CITY OF ALBUQUERQUE

May 27, 2025

RE: Parking Reduction Analysis/Self-storage at 9616 Universe Boulevard NW

Proposed Site Plan and Parking Calculations

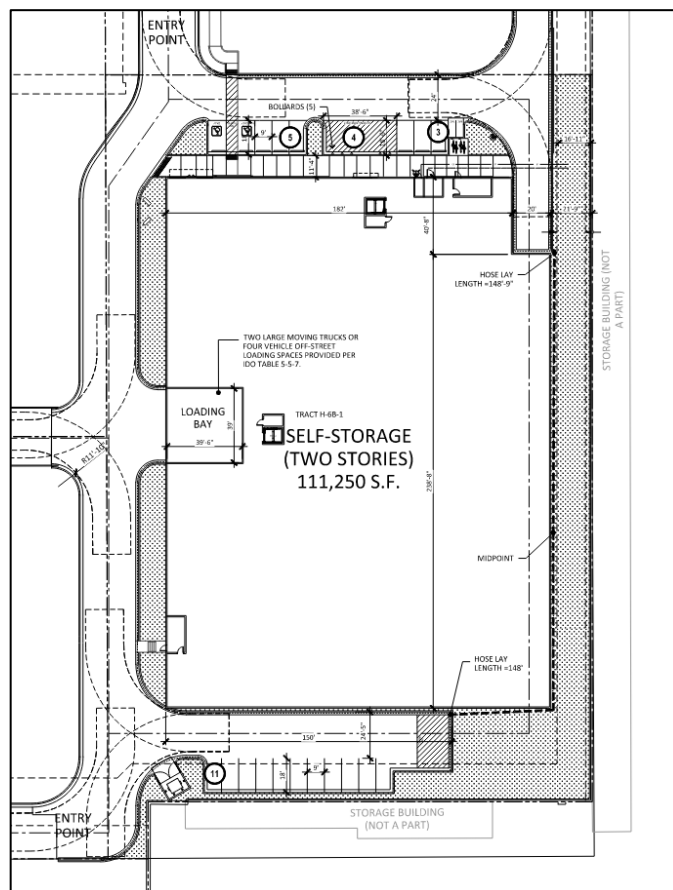
- 3) The building is fairly long and there is no access behind the building. Has Fire department reviewed the plan for accessibility.
- 4) On the notes it is mentioned that one handicap parking spaces is provided. Two handicap parking spaces as shown on the site plan should be provided based on the original required 40 parking spaces, and one must be a van handicap parking space.

- 5) On the north side of the building 4 of the spaces are not shown as actual parking spaces. Bollards are shown within the proposed parking spaces.
- 6) A detail TCL plan must be approved prior to building permit approval.

Proposed Conceptual Site Plan and Parking Calculations

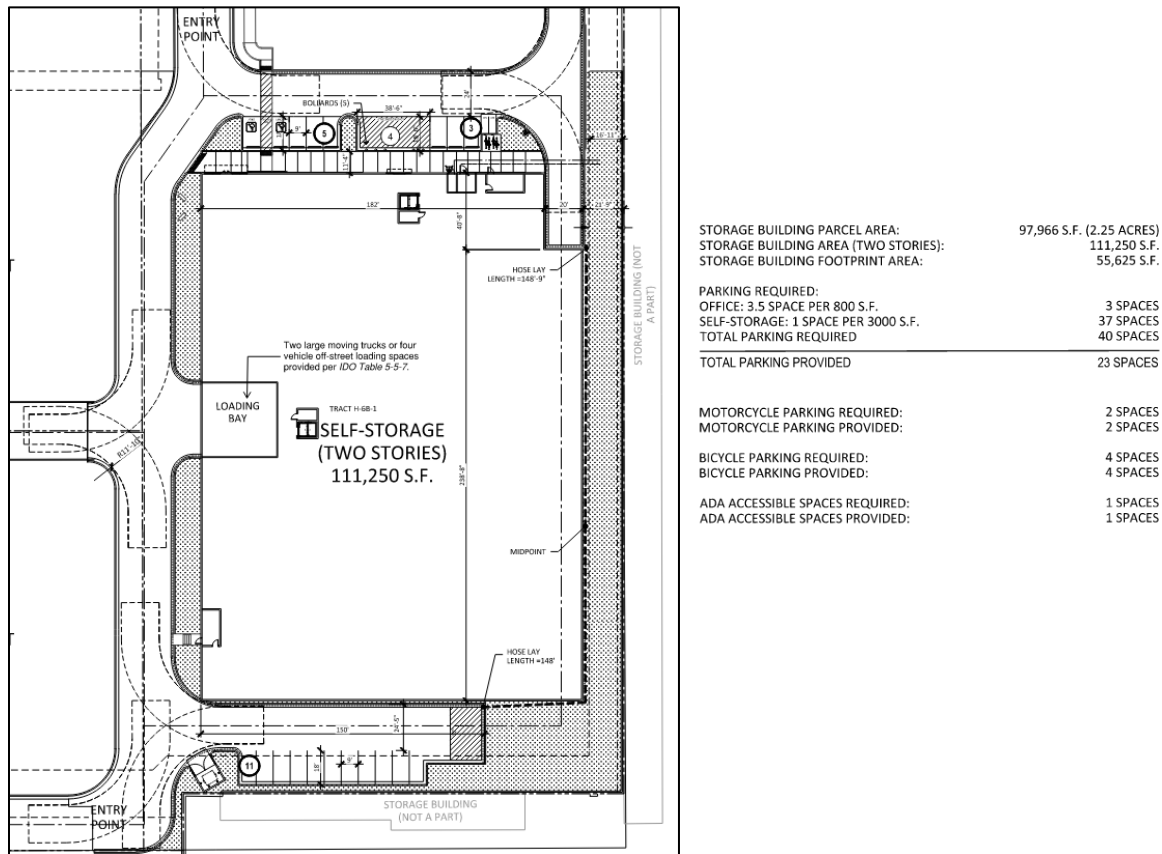
- 2) Can you clearly show the property lines. There are currently 3 lots. A replat will be required combining all lots into one. Are you going to be meeting all the required setback under the current zoning.
